**Application by FVS Dean Moor Limited for an order granting
development consent for the Dean Moor Solar Farm project**

Request for further information

Response by the Lake District National Park Authority

29 September 2025

ZTV of Works No. 1 - Solar PV
Infrastructure with View Locations

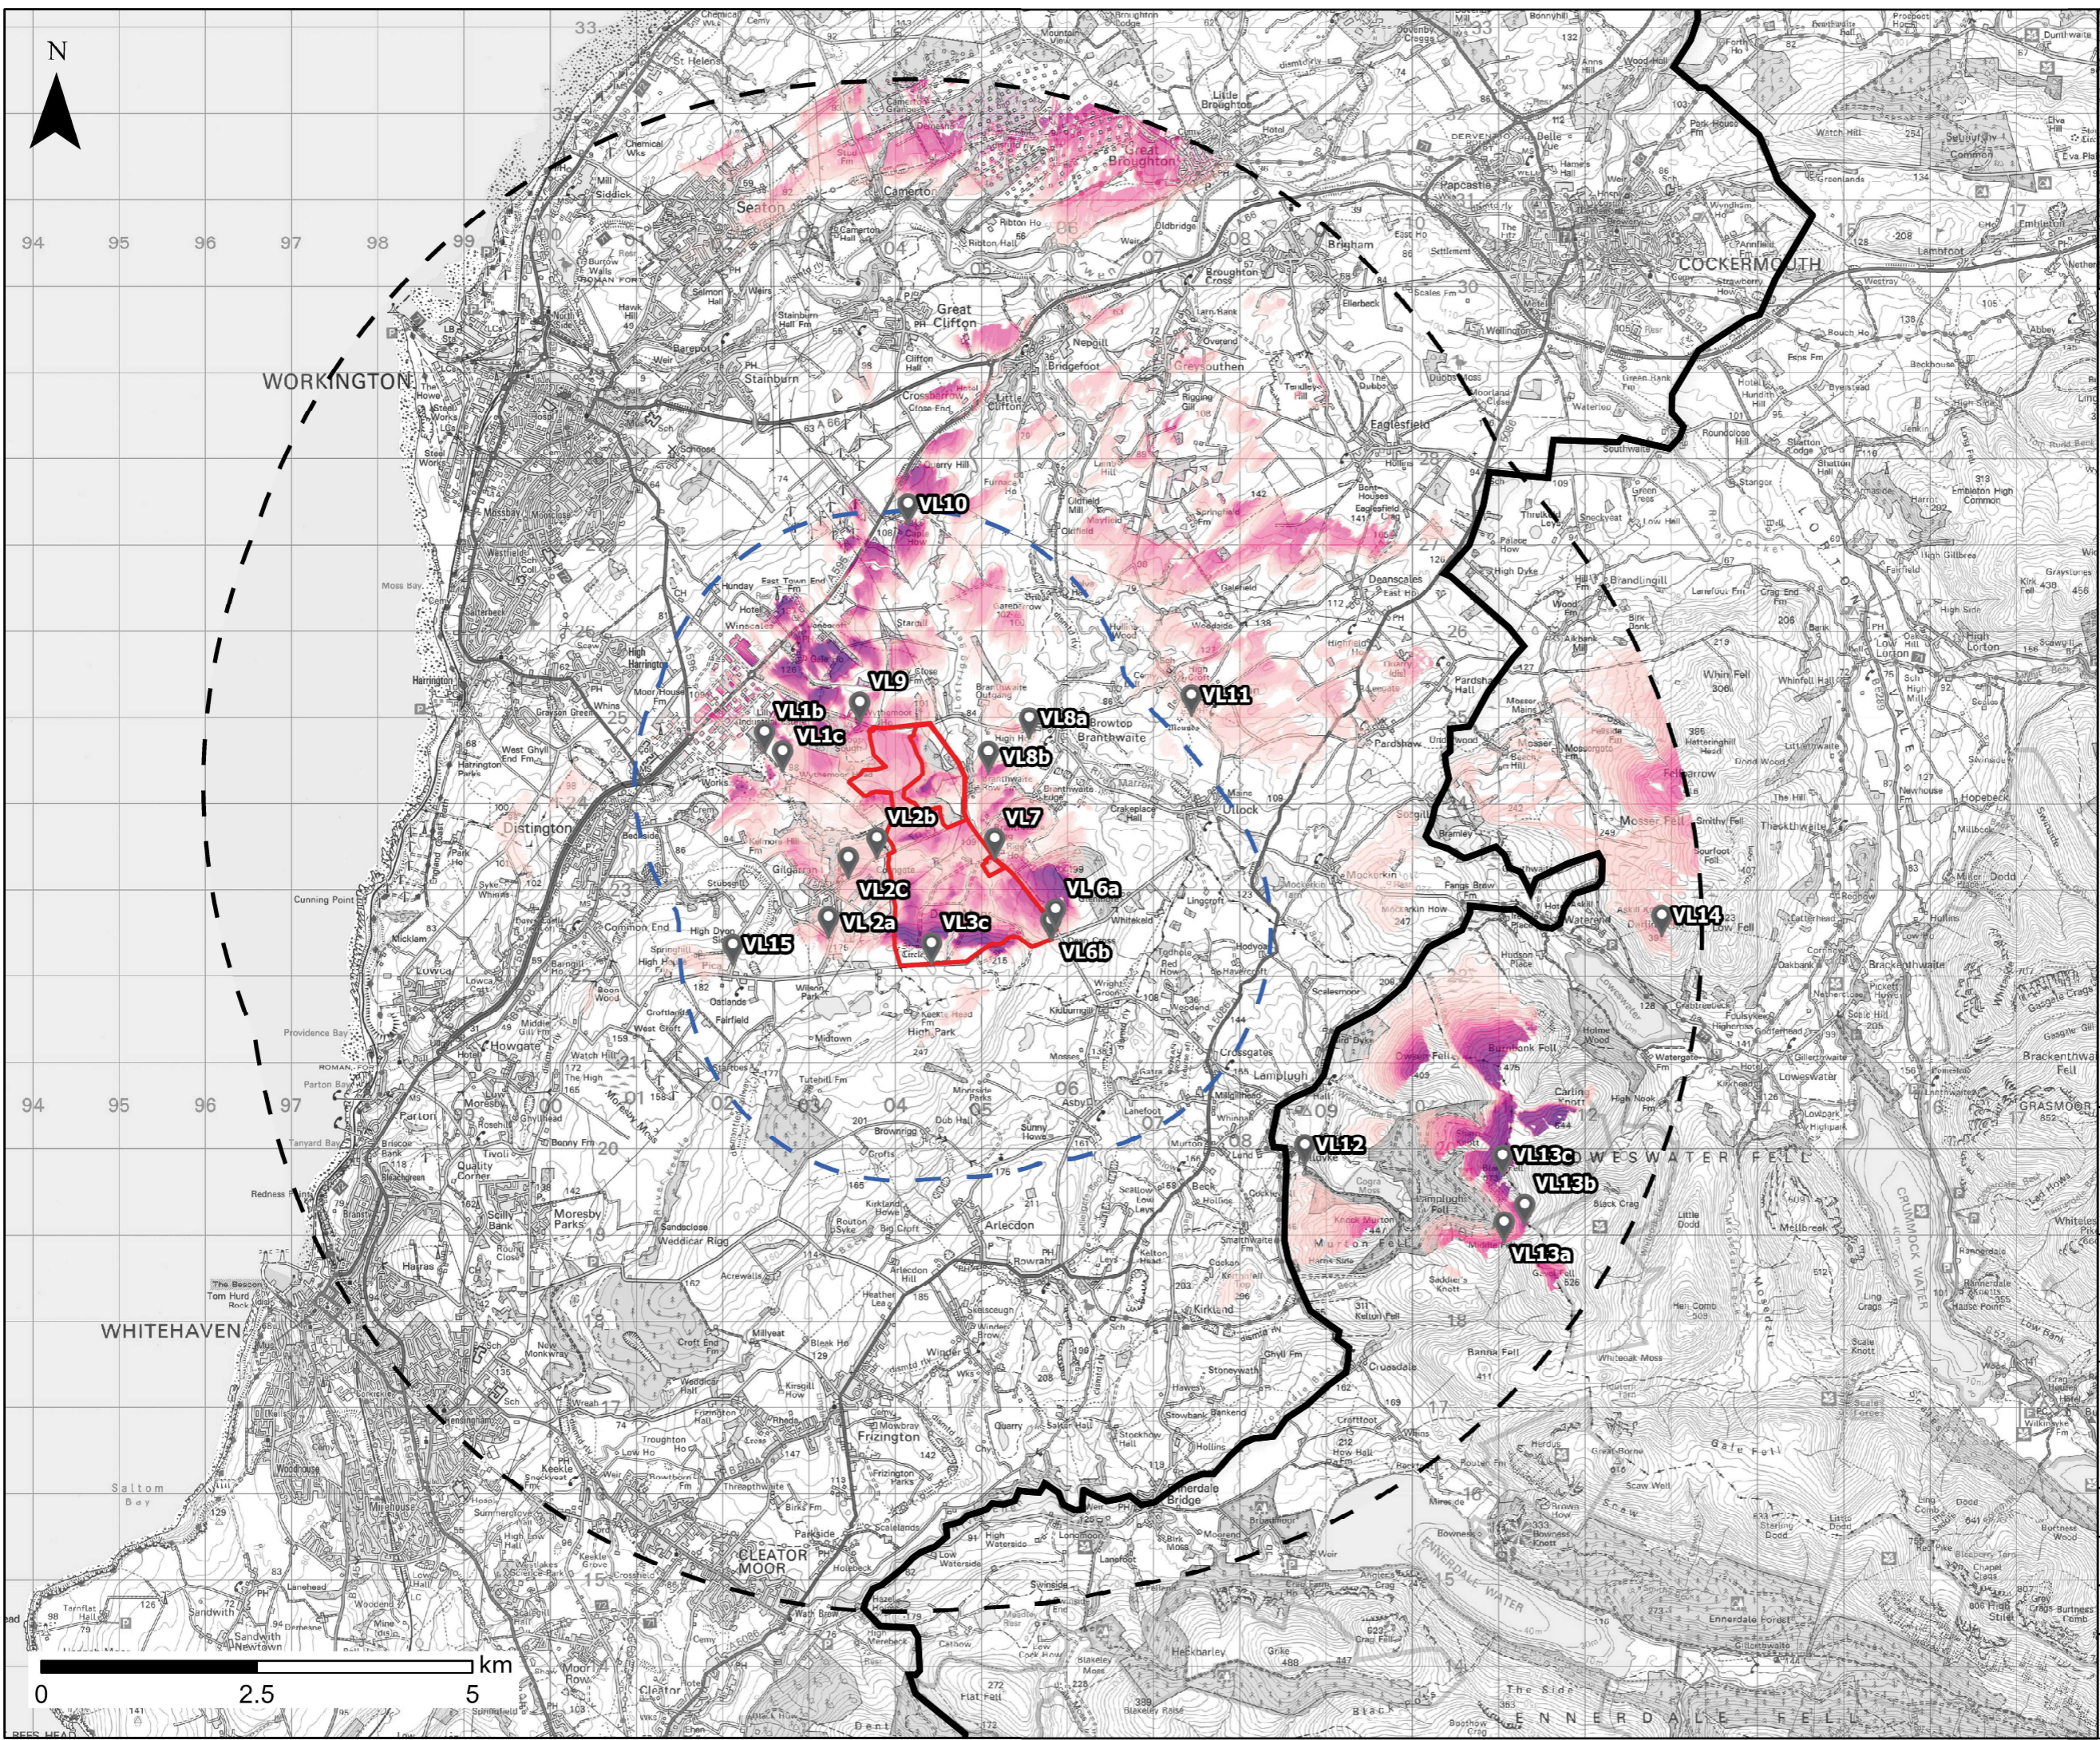
- 2.8 There are only limited views available of the development from locations within the National Park Boundary. The ZTVI mapping that has been

provided appears to show a greater area within the National Park than we have observed from our ground truthing, as being affected.

- 2.10 The particular views we have identified as being affected are:
1. Fellbarrow (represented by viewpoint 14): The fell is included in the Wainwright Western Fells book (included in the 214 'Wainwright' summits). Fellbarrow stands between 8 and 9km west from the site. The view from the summit is described as: '*Fellbarrow stands on the fringe of the high country, and to the north and west there is a wide and uninterrupted view of the coastal plain of Workington and district and across the Solway Firth to the Scottish hills, a scene predominantly rural but with some obvious evidences of urban development and industry*'. Parts of the site are visible from the summit and the upper western flanks. Due to the position of Branthwaite Edge, the main portion of the site (Area C) would be less prominent from this location, the areas A and B would be more visible.

2. Blake Fell and Burnbank Fell (represented by view points 13, 13a and 13b): Blake Fell and Burnbank Fell are also included in Wainwrights Western Fells book, Blake Fell being '*the highest of the Loweswater uplands*', and as such is a popular climb. Again, views seawards are described as uninterrupted and '*the West Cumberland coastal area is revealed in detail*'. These fells stand 7-8km south west of the site. Parts of the site are visible from the summit and the upper western flanks including the subsidiary summit of Knock Murton. From the summits views are available over the intervening ridge to a substantial portion of the site.
